**Subject: Eileen O'Connor Catholic School (SSD-67173718) – Environmental Impact Statement**

Thank you for your Major Projects Portal request dated 24 July 2025 seeking advice from the Conservation Programs, Heritage & Regulation Group (CPHR) of the NSW Department of Climate Change, Energy, the Environment and Water (the department) on the Environmental Impact Statement (EIS) for Eileen O'Connor Catholic School (SSD-67173718).

## Attachment 1 - CPHR Assessment Summary for Eileen O’Connor Catholic School Environmental Impact Statement (SSD-67173718)

Flood Types - Short and Long
Duration Response Times

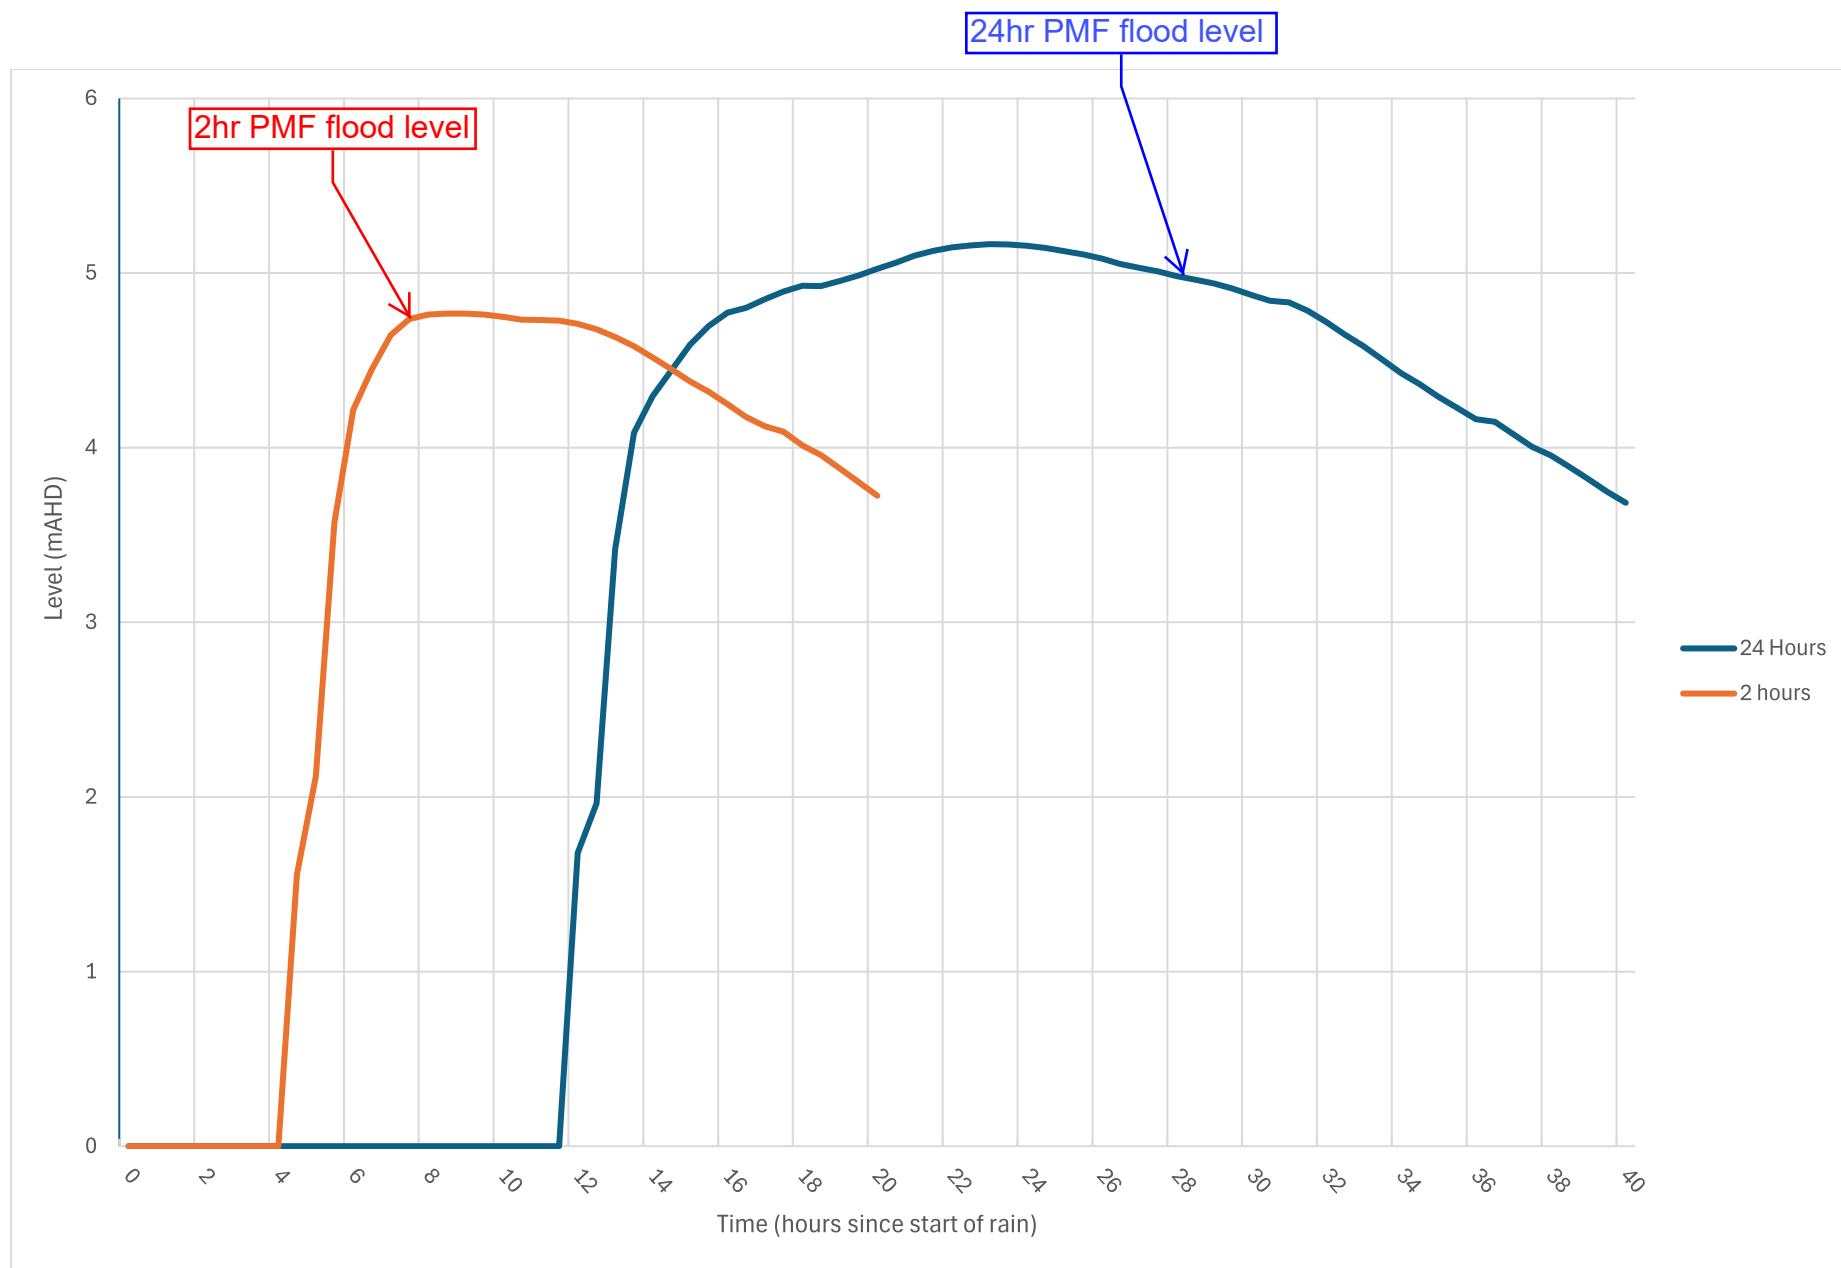
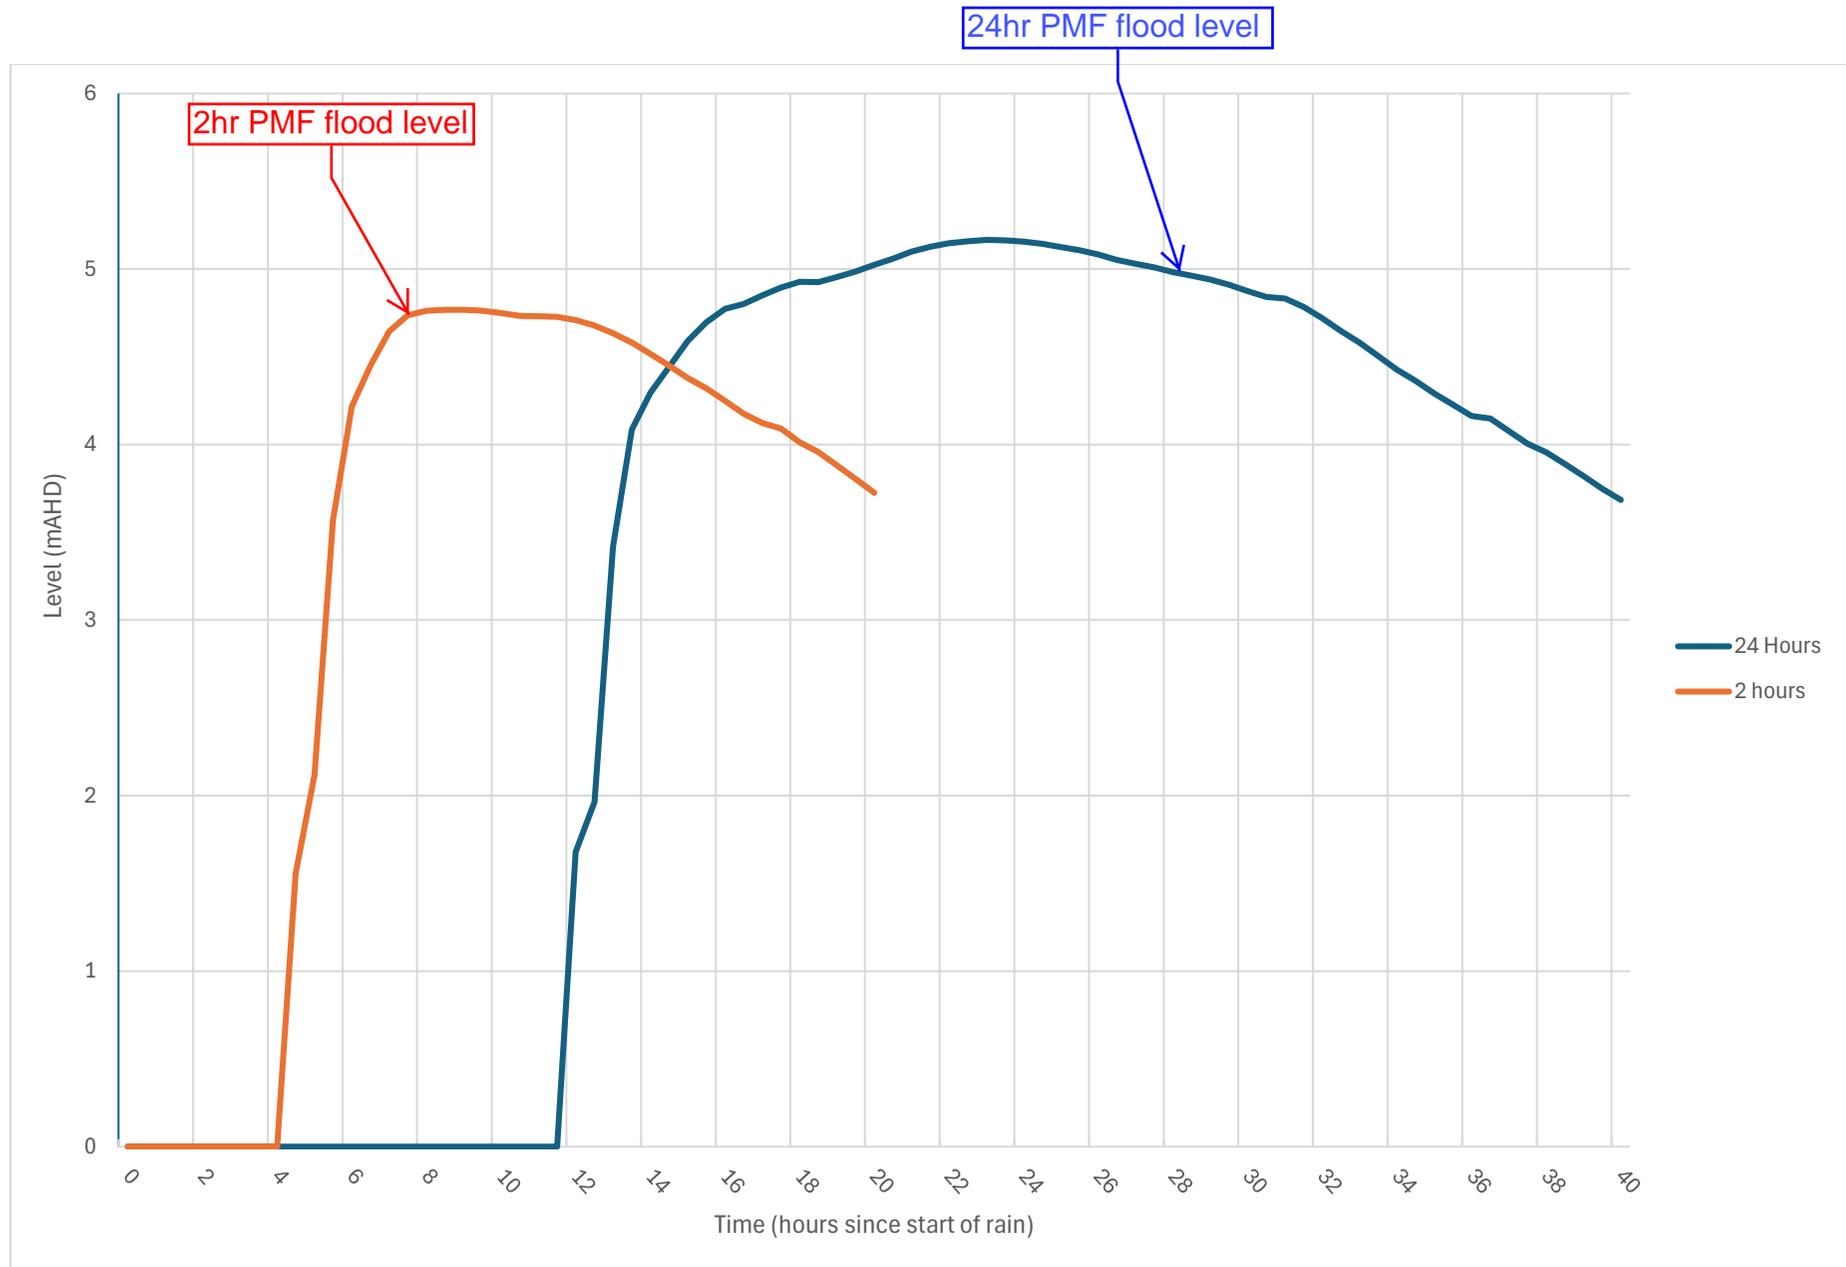
1.	<b><i>The FIRA does not contain the level of detail that is commensurate with the flood risk at the site</i></b>	<p>The Flood Impact and Risk Assessment (FIRA) prepared by Tooker and Associates (June 2025) lacks sufficient detail to adequately assess flood risk at the site. The FIRA does not address the full range of flood events, from frequent to Probable Maximum Flood (PMF), nor consider climate change impacts on flood behaviour.</p> <p>Existing information provided is limited to progression of hazard ratings at point locations along the proposed evacuation route for 2-hour and 24-hour PMF only. It is likely that the school may also be isolated in frequent flood events.</p>
	<i>Recommended action</i>	<ul style="list-style-type: none"> <li>• Update the FIRA to comply with <i>Flood Impact and Risk Assessment LU01</i> and <i>Understanding and Managing Flood Risk FB01</i>. The FIRA should provide hydrographs, frequency and duration of isolation for the full range of flood events covering short and long duration storms.</li> </ul>

The FERP does not include a timeline analysis estimating the time available for evacuation which would identify when specific emergency management actions should occur. This analysis must address the following key components:

<ul style="list-style-type: none"> <li>○ Available warning time: The duration between the issuance of a flood warning and the onset of hazardous conditions.</li> <li>○ Evacuation time: The time required to safely evacuate all individuals once evacuation triggers are activated.</li> <li>○ Isolation duration: The expected length of time individuals may need to shelter in place due to inaccessible evacuation routes.</li> </ul> <ul style="list-style-type: none"> <li>● <u>Essential Flood Evacuation Safety Measures:</u> The FERP should include a schedule for annual inspection and maintenance of critical safety measures, including: <ul style="list-style-type: none"> <li>○ Drinking water, long-life food, and firefighting equipment</li> <li>○ First aid kits</li> <li>○ Medical records and emergency contact information</li> <li>○ Automatic flood warning systems</li> <li>○ Emergency lighting and. backup power</li> <li>○ Evacuation signage</li> </ul> </li> <li>● <u>Secondary risks associated with shelter-in-place:</u> The FERP has not considered how secondary risks such as medical emergencies, fire, and loss of utilities will be managed. The <i>Shelter in place guideline for flash flooding</i> (DPHI, 2025) and <i>Support for Emergency Management Planning EM01 (Table 12)</i> both emphasise the need to assess and mitigate these risks to ensure safe sheltering. The Flood Risk Management Manual (FRMM) also highlights the importance of considering vulnerability and resilience in emergency planning.</li> </ul>

<i>Recommended action</i>	Engage a suitably qualified flood risk and emergency management consultant to revise the FERP to demonstrate that risk to life can be appropriately managed and so that it includes clear, quantifiable triggers for each emergency management action.
	<i>Extent and Timing</i>	Pre-determination

Westfield Shopping Centre Flood Refuge

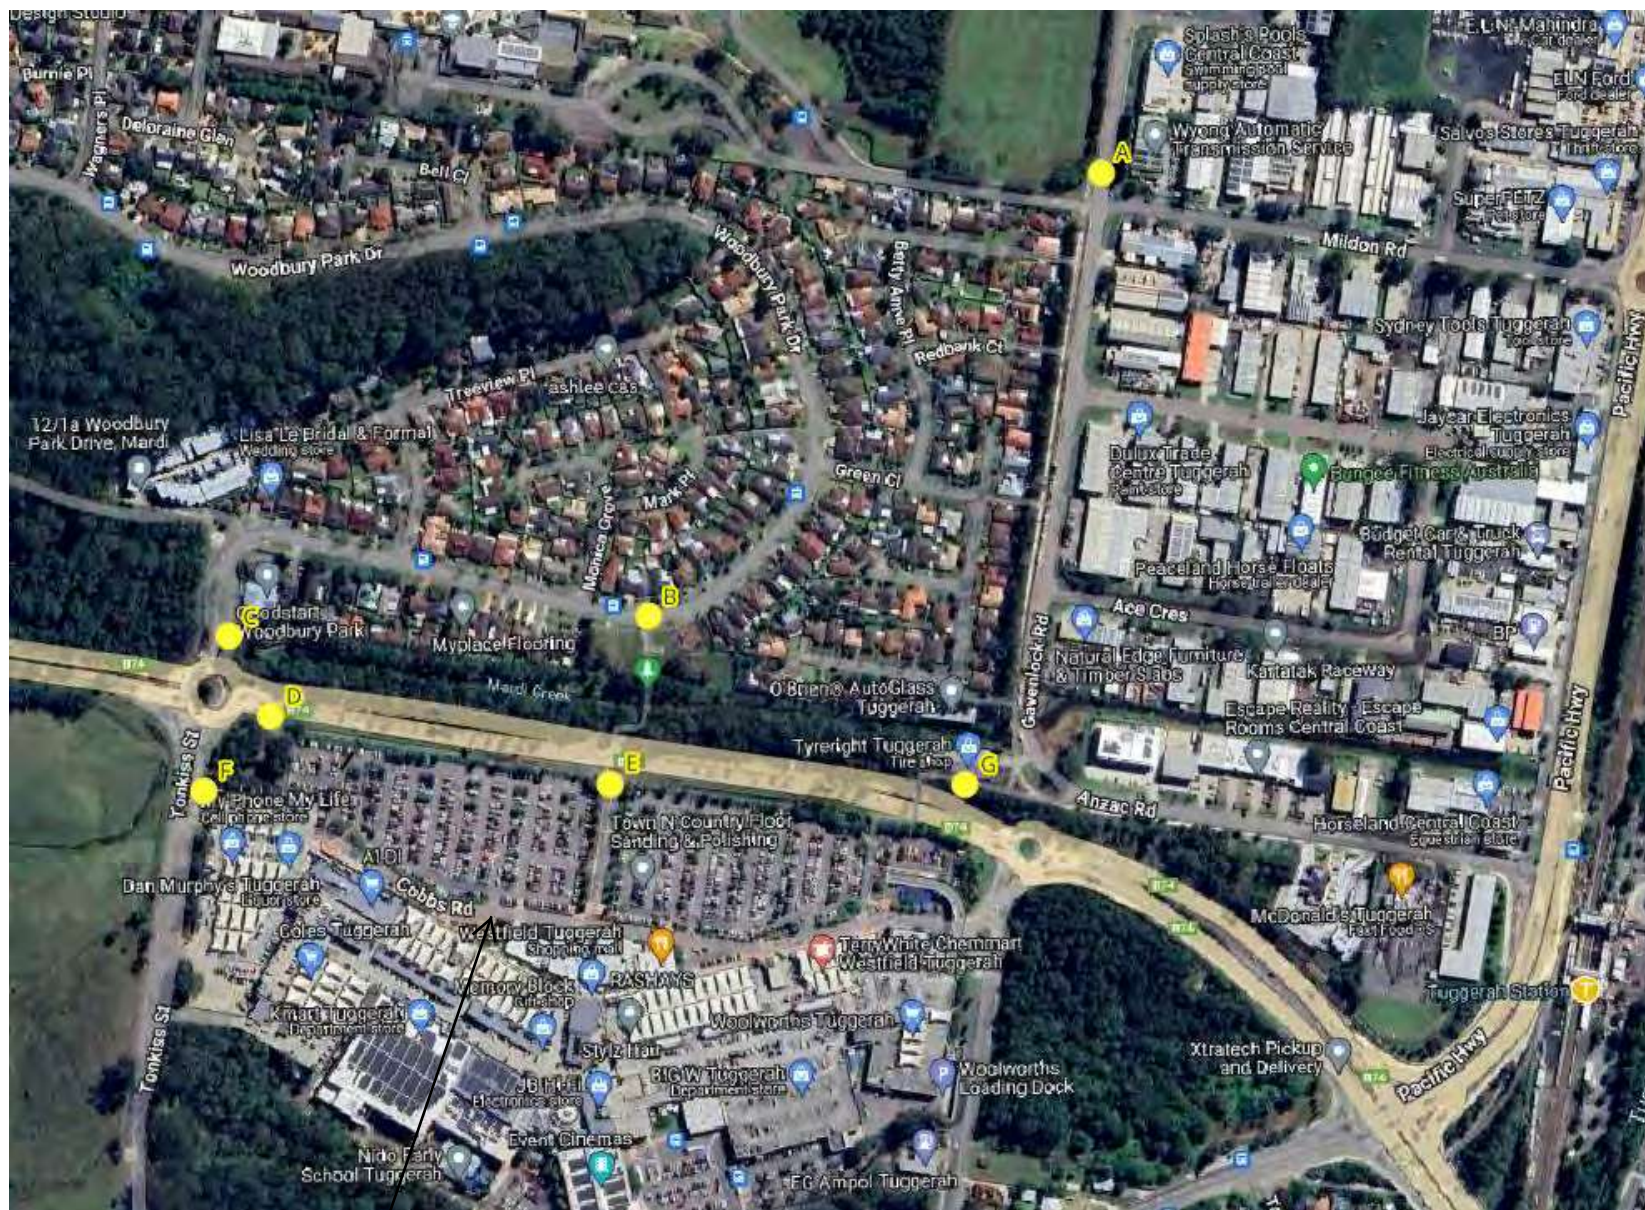
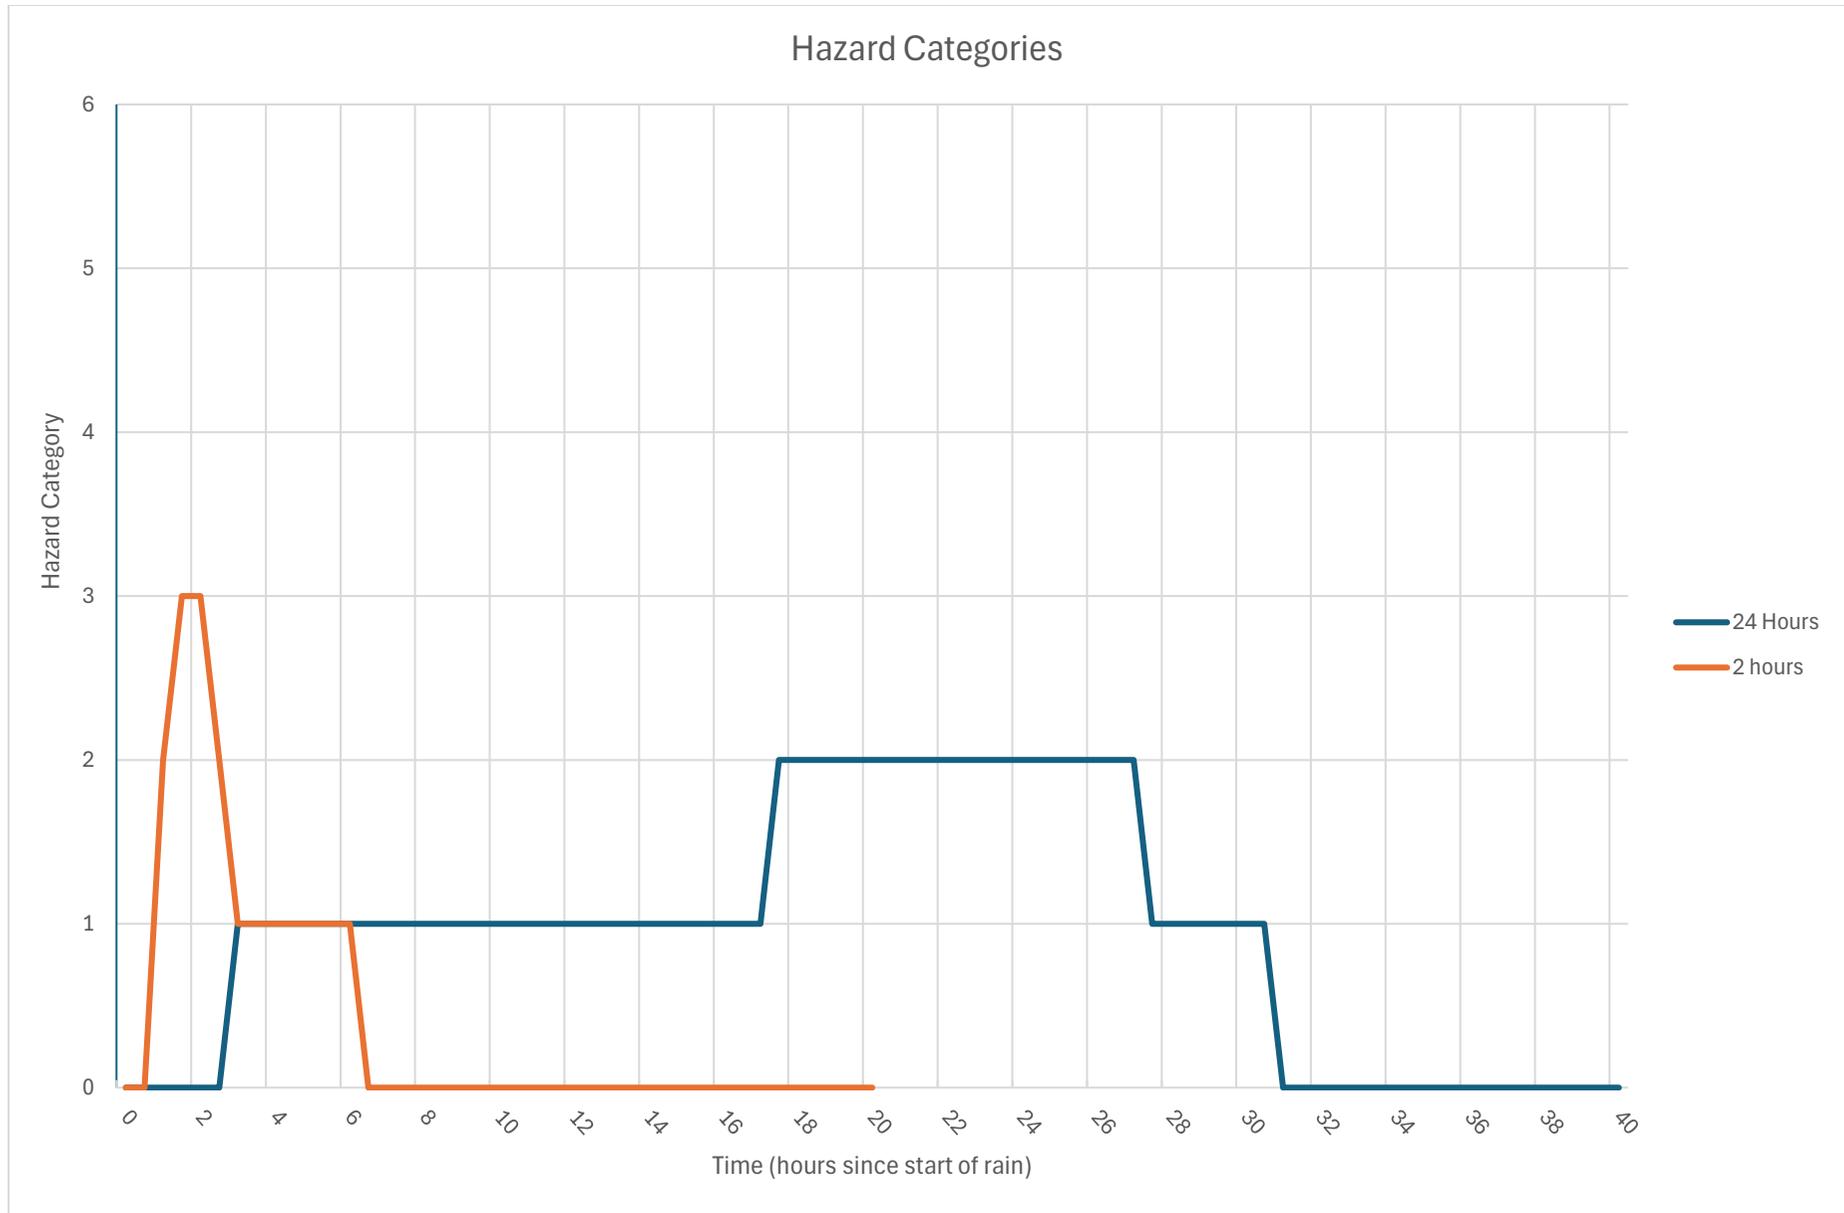
- Adequacy of the proposed off-site refuge:

The FERP proposes Westfield Tuggerah Shopping Centre as a flood refuge. However:

- The centre is not an approved evacuation facility.
- There is no evidence of consultation with the centre management.
- The facility may be unavailable during extreme events due to staffing, infrastructure damage, or utility outages.
- It is unclear whether the centre can accommodate students with special needs.
